PLANNING STATEMENT - ADDENDUM

SITE: 77 ALDWICK ROAD, BOGNOR REGIS, WEST SUSSEX, PO21 2NW

PROJECT: PART CHANGE OF USE OF GROUND FLOOR & FORMATION OF A FIRST FLOOR REAR EXTENSION TO CREATE 2 NO SELF-CONTAINED STUDIO FLATS WITH ASSOCIATED REFUSE / RECYCLING & CYCLE STORE (RE-SUBMISSION FOLLOWING BR/233/19/PL)

1357/P03 D

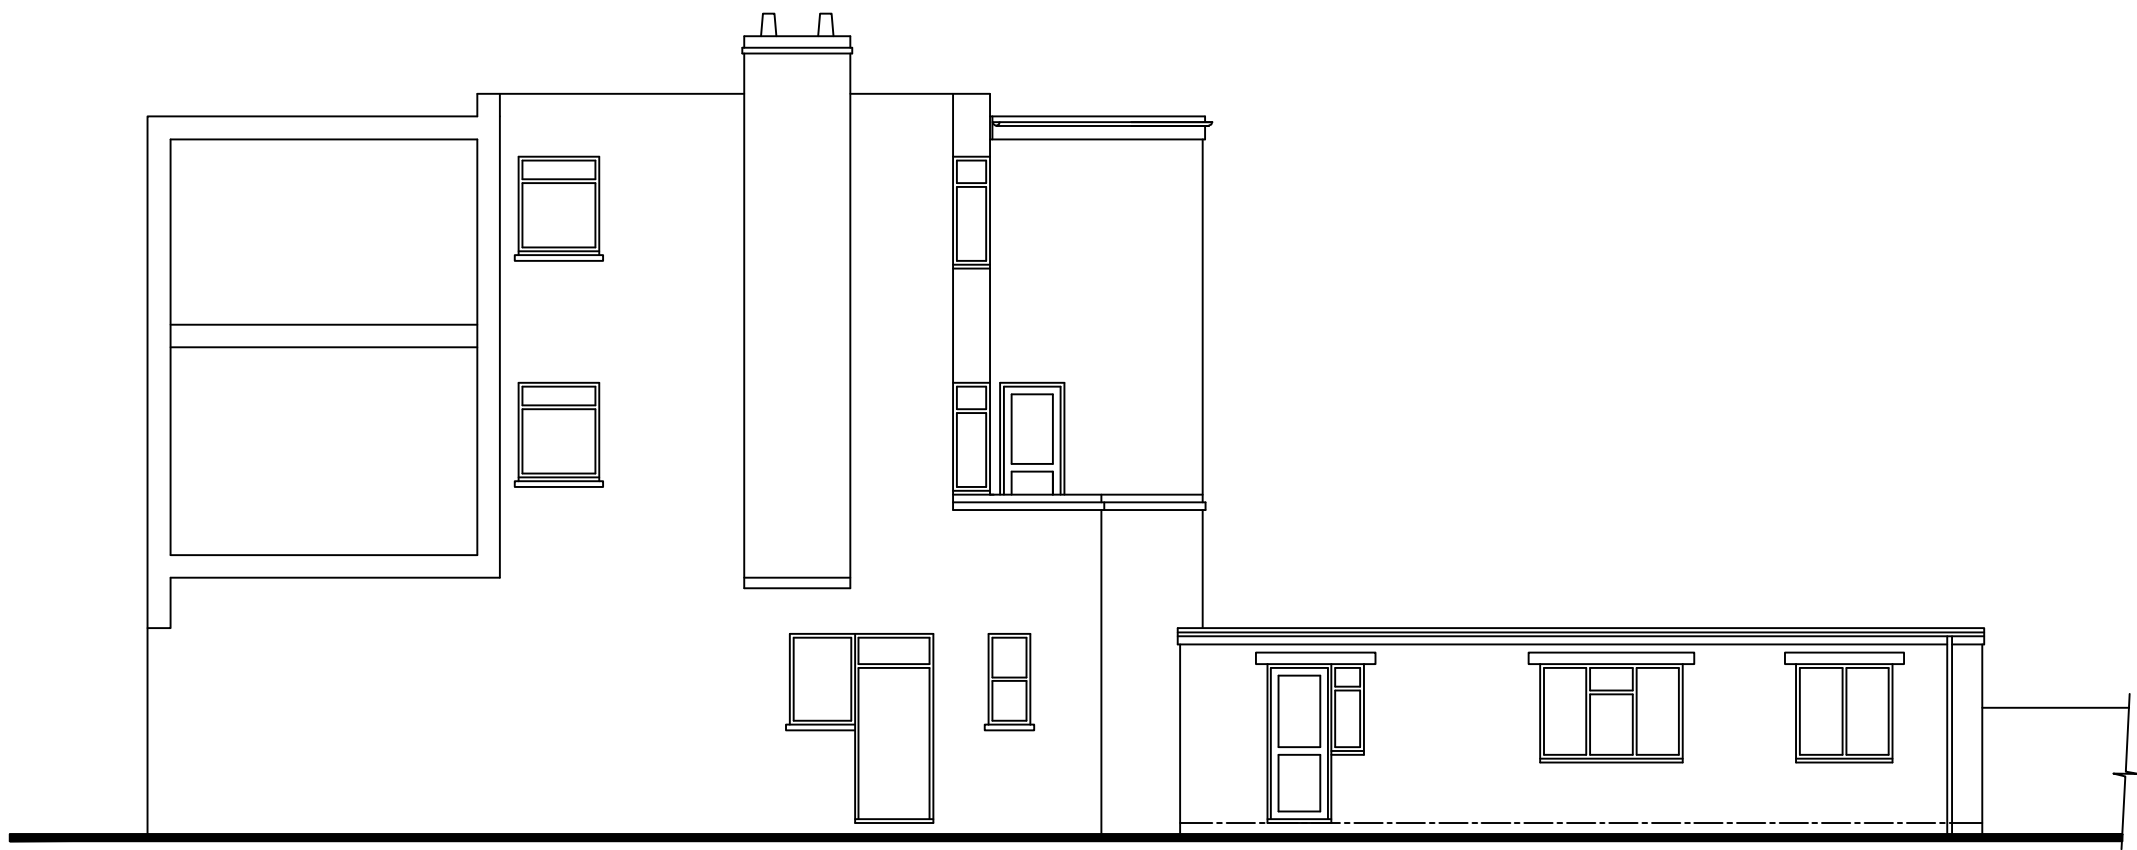
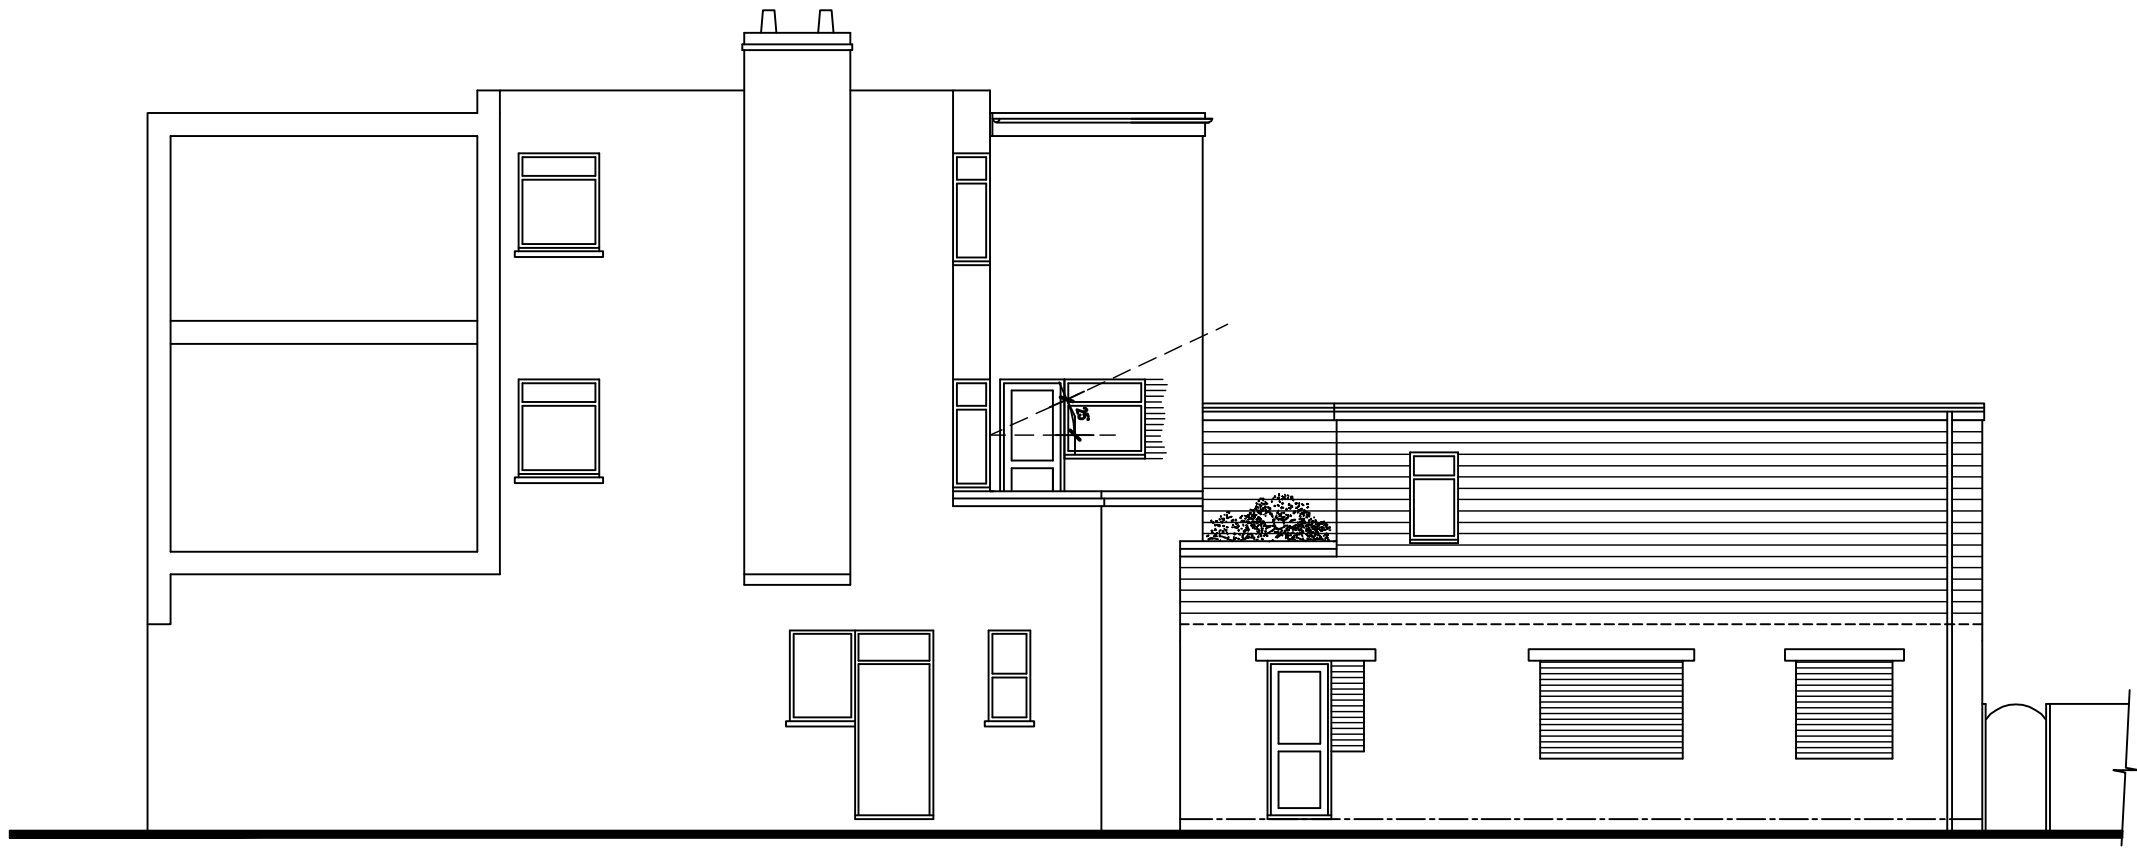
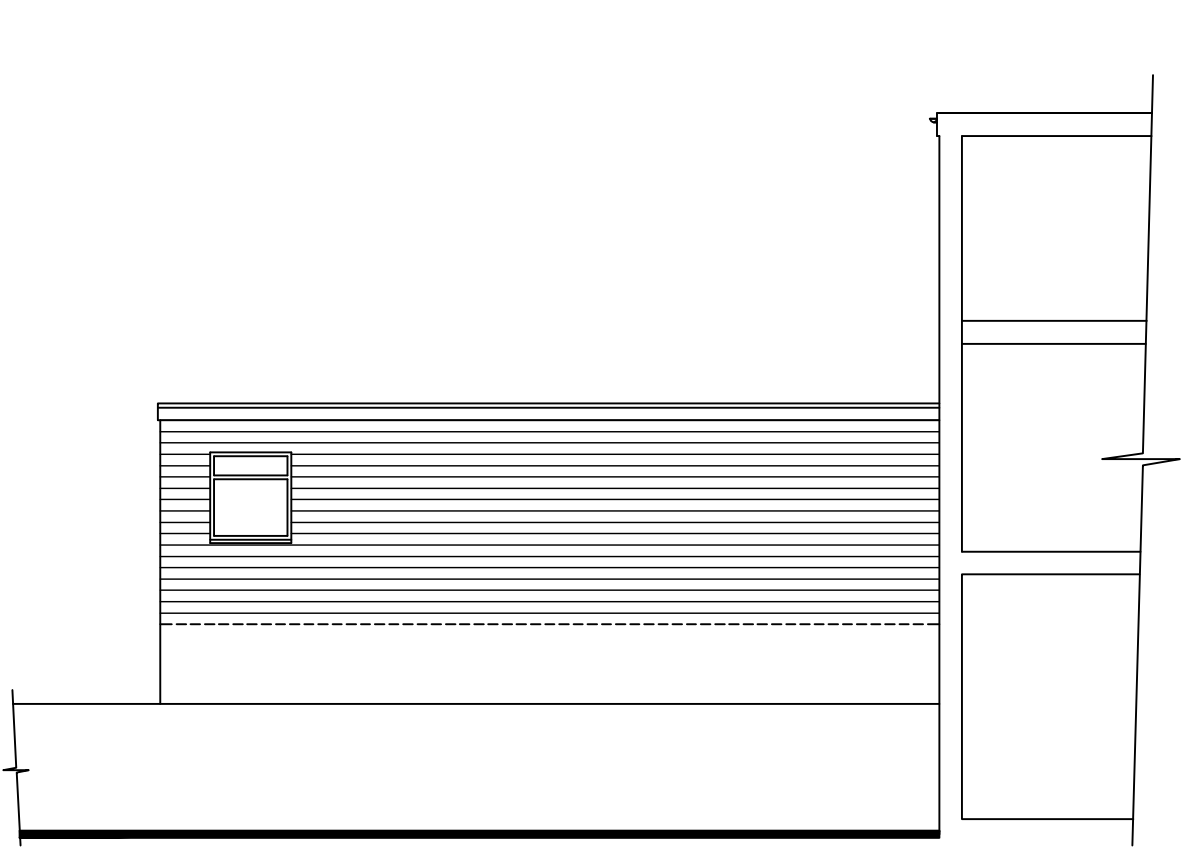
- 4.1.1 The amendments made to application ref BR/233/19/PL are essentially twofold: firstly, the proposed northern wall of the first floor extension would be positioned further to the south thereby opening up a greater gap to the host building; and secondly, the first floor window on the rear elevation will be re-sited further to the west and a new secondary window shall be opened up in the southern part of the eastern flank wall.

- 4.1.9 The proposed amendment has re-sited the window opening in the rear elevation to the far western side of the extension, thereby creating an even more oblique and more difficult view into the rear garden of 10 Stocker Road than would otherwise have existed under the previously refused scheme. In order to provide more daylight into the rear of the flat, and to provide additional scope for obscurely glazing the rear window in full or in part, a new secondary opening has been proposed at the southern end of the east facing flank elevation. This window opening would provide additional daylight and outlook for the proposed first floor dwelling and owing to the orientation of the window it would not overlook any neighbouring residential properties.
